Our Ref: MN/7451/App\_240621.  
24<sup>th</sup> June 2021

**Re: Planning application at 69-71 Church Road, Anerley, Crystal Palace, SE19 2TA  
Variation of Conditions 2 & 9 Application – Submitting of comparison drawings.**

In response to the invalidation letter dated 16<sup>th</sup> June for the Variation application for the project at 69-71 Church Road, Anerley, ref: DC/19/03203/RECON, I attach the following drawings with the original approved drawings overlaid in red, as requested, for your consideration.

Drawing No. **7451-PD-208** Revision

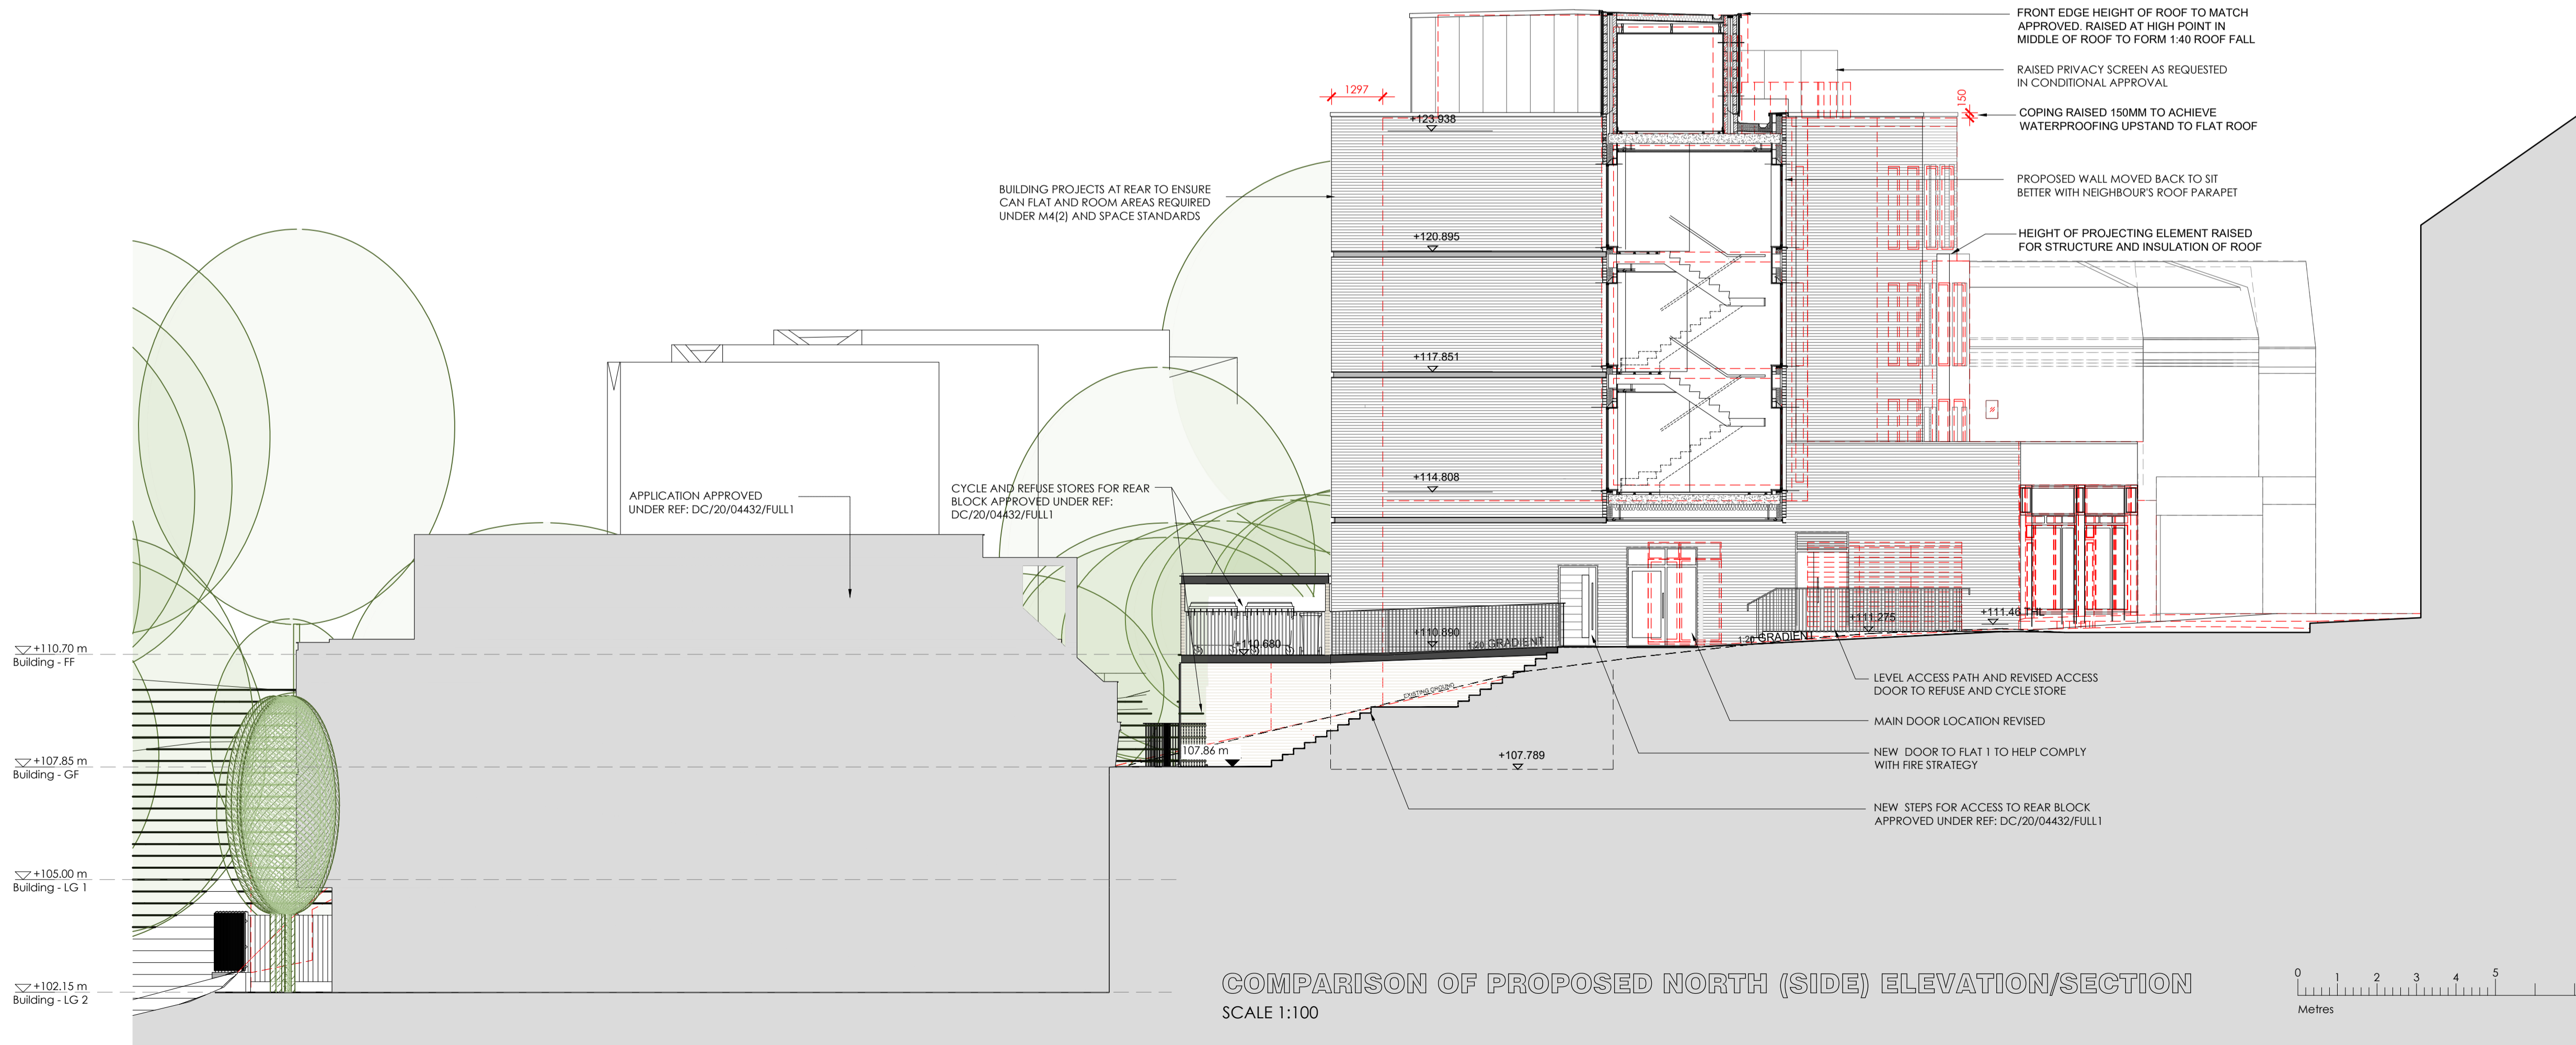
Drawing **7451-PD-208** South & North Sections

- Overall height remains as approved. Parapet at terrace level raised approx 150mm to allow for insulation to roof and waterproofing upstand.
- Rear of building extended to allow for necessary internal layout changes to enable compliance with building regulations, space standards and AD M4(2) (Noted as requirement for previously approved scheme).

- Floor and wall thicknesses increased where required to achieve required thermal and sound insulation properties to comply with Building Regulations.
- Angle of front wall of residential units revised to gain required space to comply with flat / room sizes / furniture layouts.

Project No.	Date
7451	JUNE 2021
Drawing No.	Revision
7451-PD-206	
Scale	Drawn
1:100 @ A1	MN
	Check
	RC

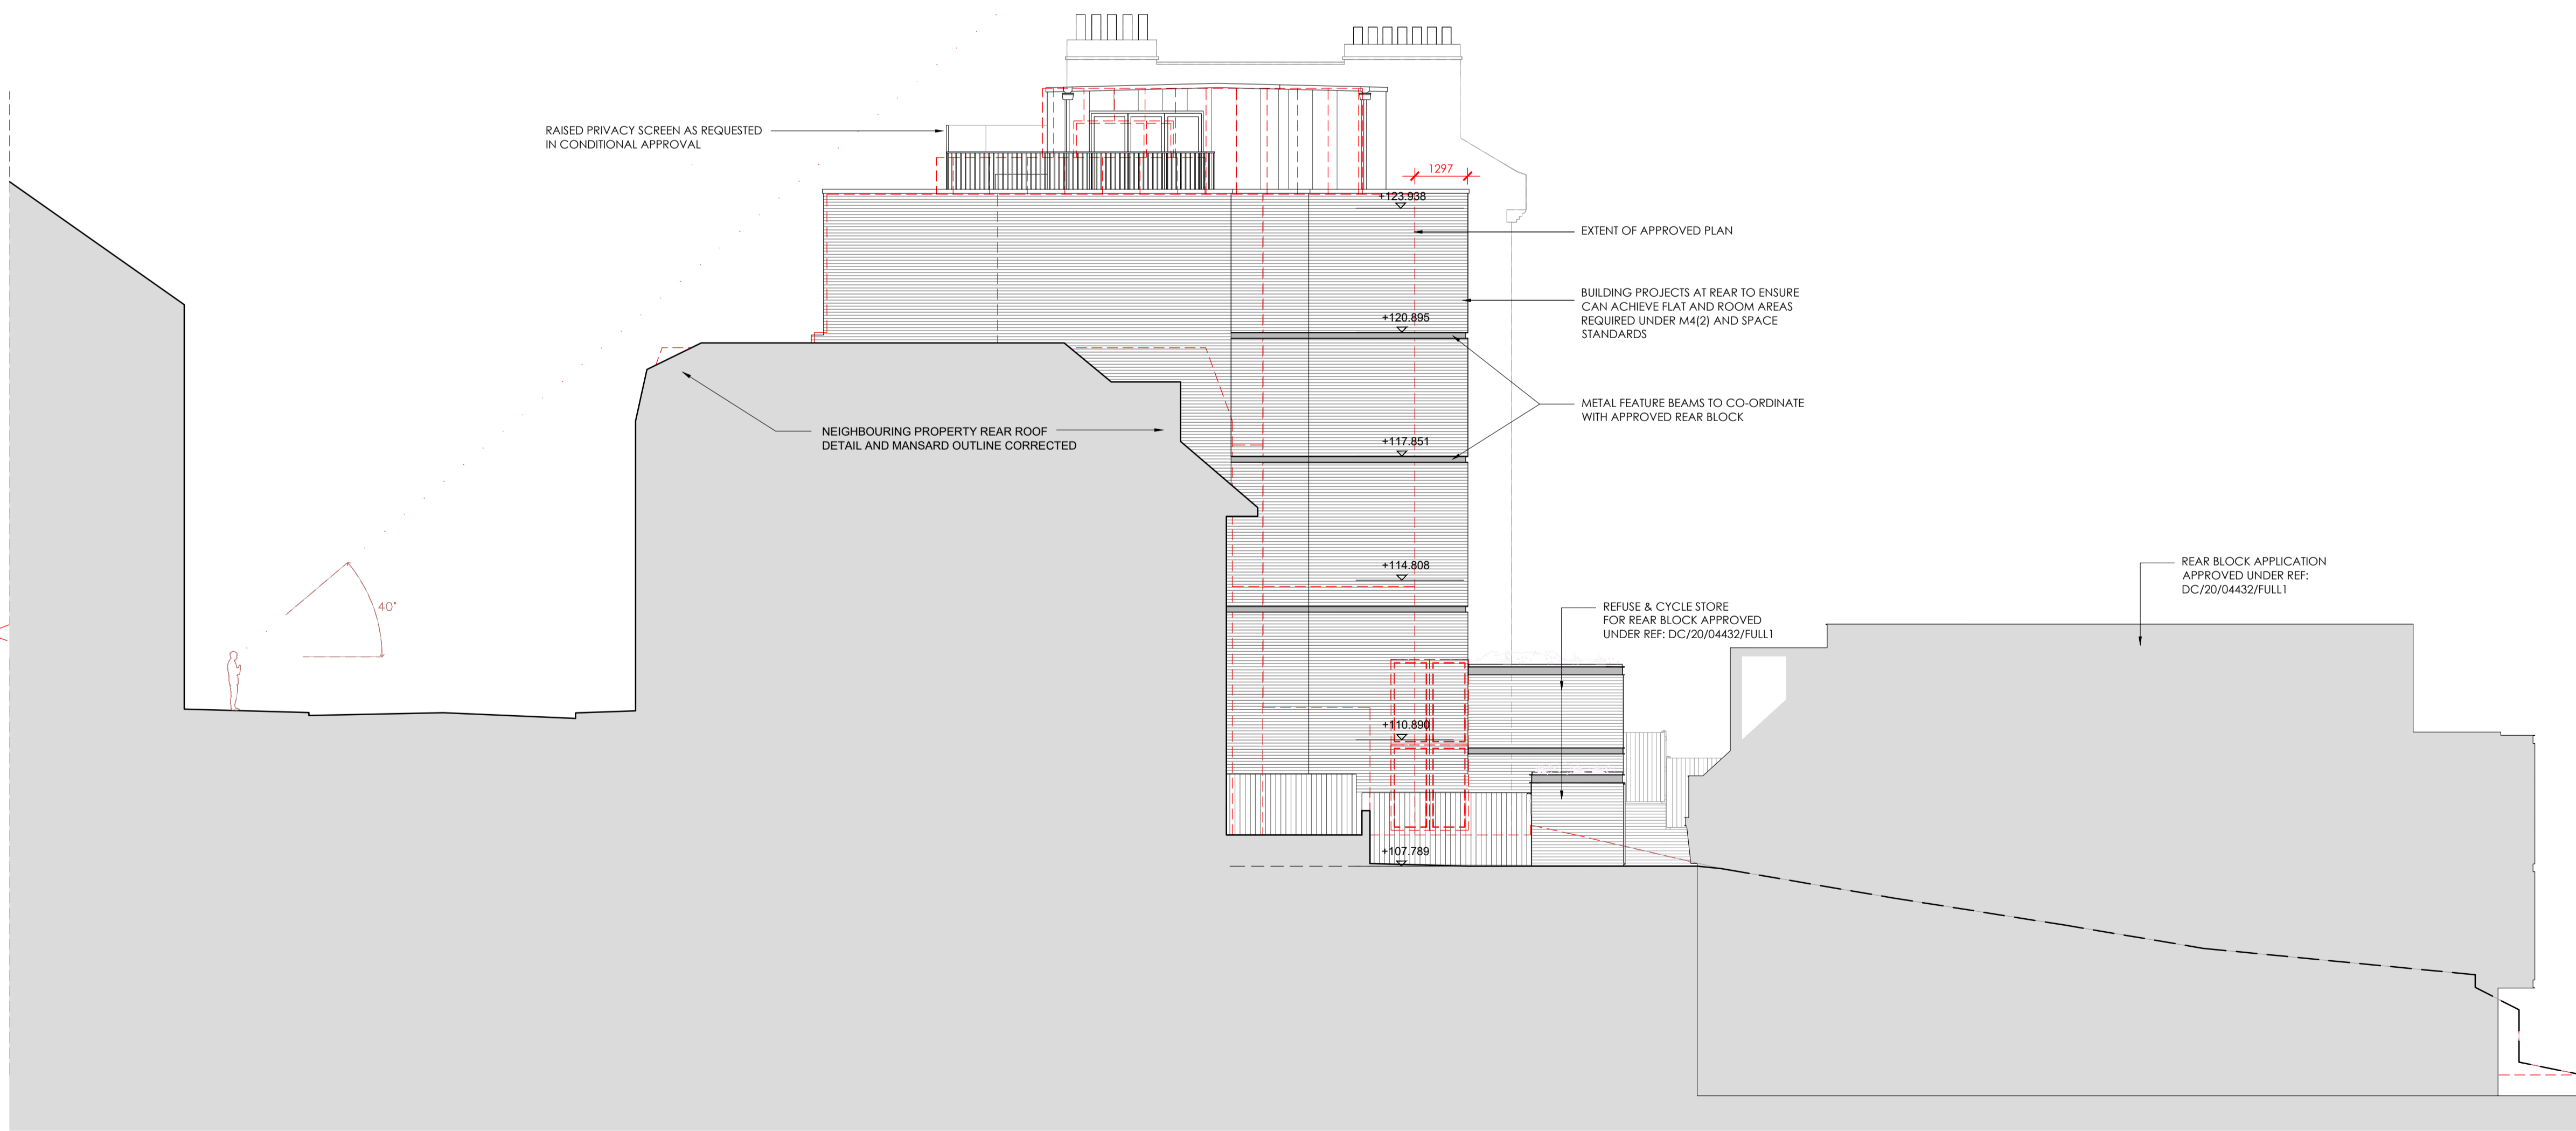
Drawing **7451-PD-206** West (Front) & South (side) Elevations

- Doors to side elevation altered to simplify cycle/bin store access and to add external entrance door to flat 1 to comply with Building Control fire strategy.

- Windows relatively unchanged but positions revised slightly to suit internal layouts and necessary structural elements.
- Windows added to recessed elevation at rear to coordinate with plans. The approved plans had windows shown on plans but not on elevation.

- Some elements of render replaced with brickwork.
- Steel feature beams added to rear to link design with approved building at rear of site.
- Privacy screen, as requested on conditional approval notice, to roof terrace raised and formed with frosted glass.
